Date: 24 January 2019

**Re: Submission of details pursuant to condition 3 (Archaeological Written Scheme of Investigation) on planning permission 6/2017/2972/FULL - Stanborough School Lemsford Lane Welwyn Garden City AL8 6YR**

Figure 2

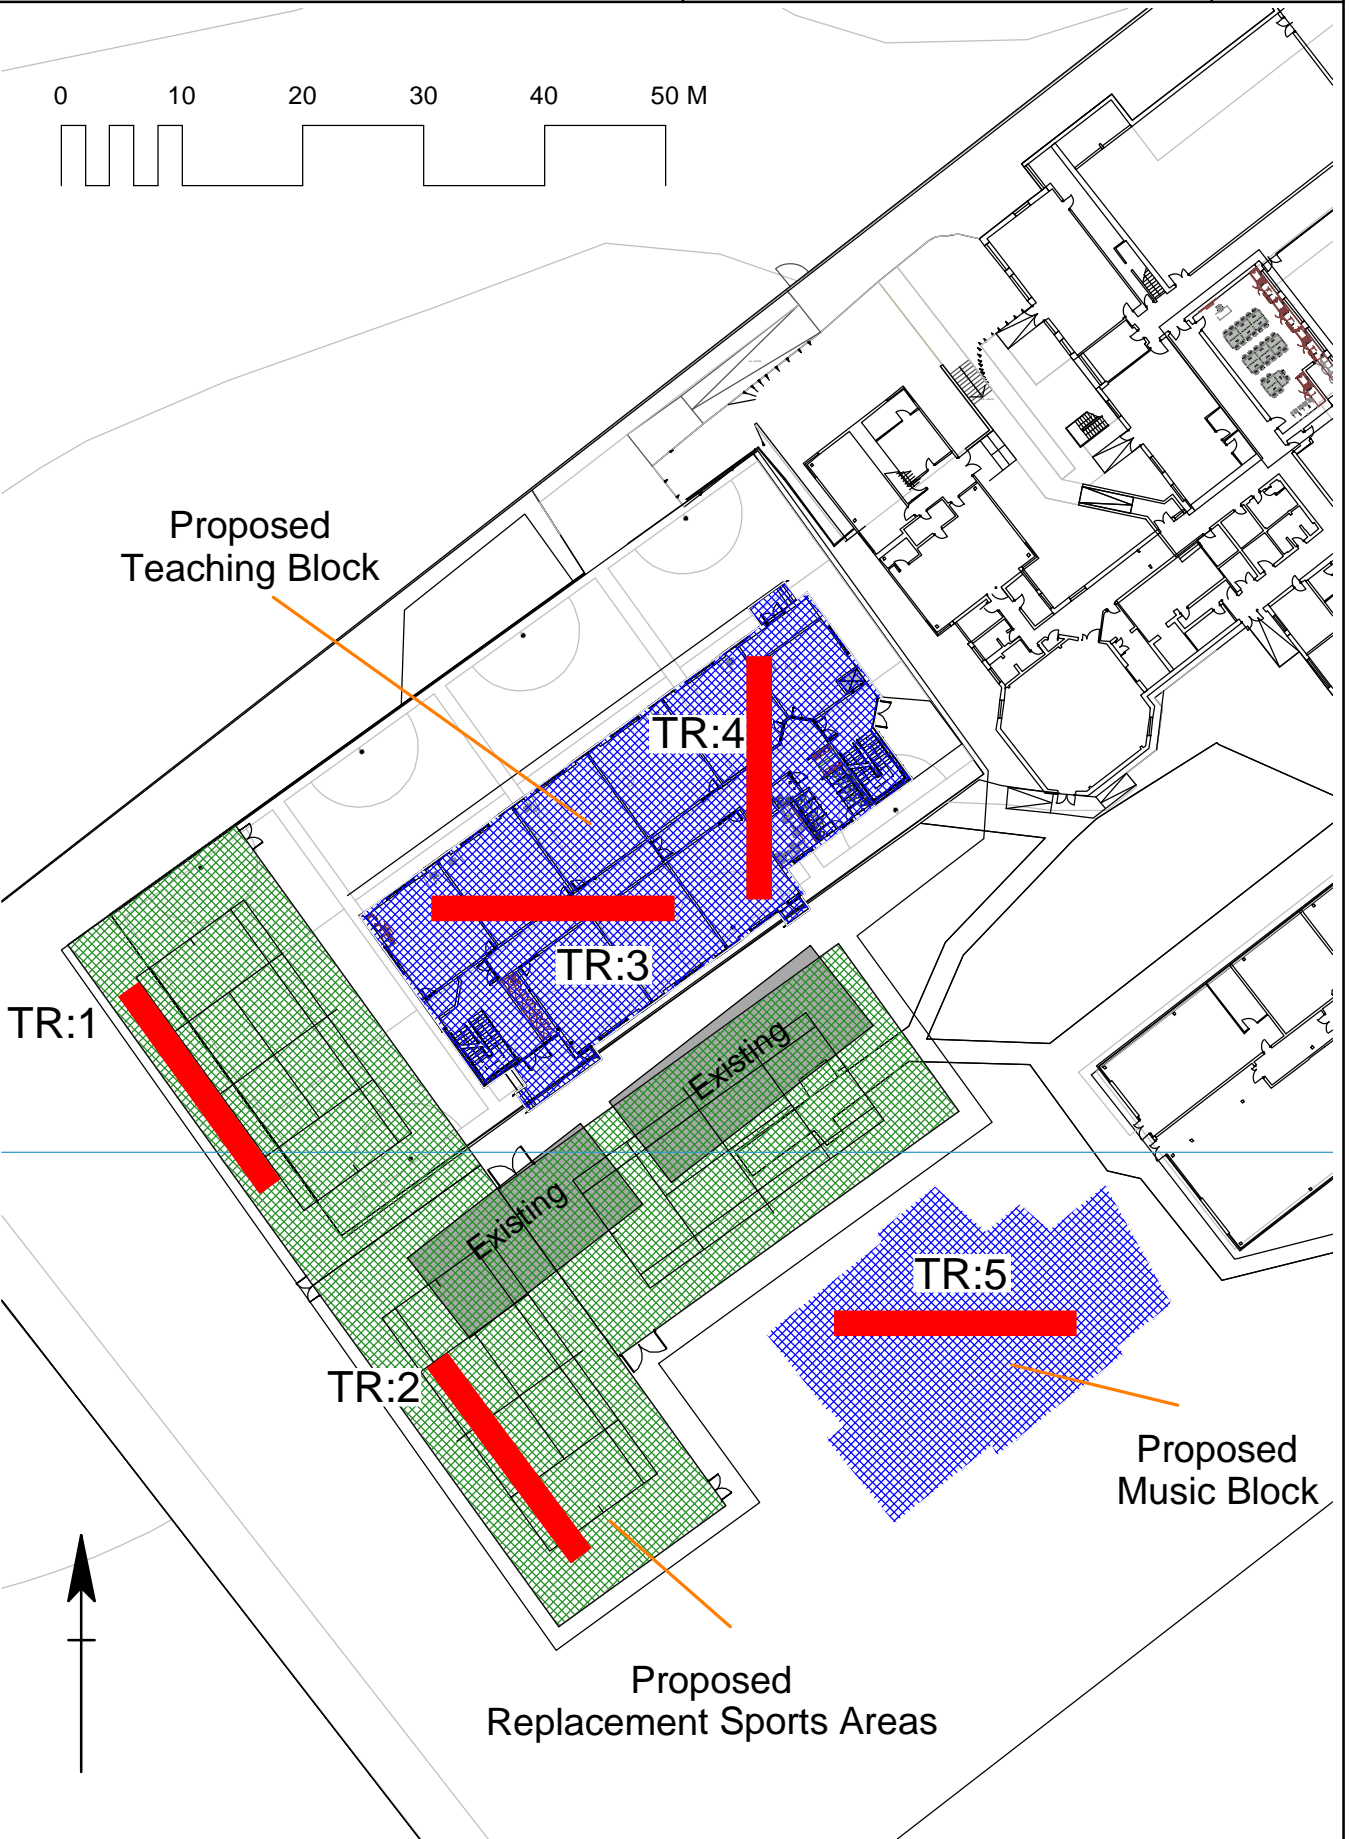
We do have some queries regarding the distribution of trenches in Figure 2. The gap in trenching in the very centre of site should ideally be filled with an additional trench, preferably running NE-SW.
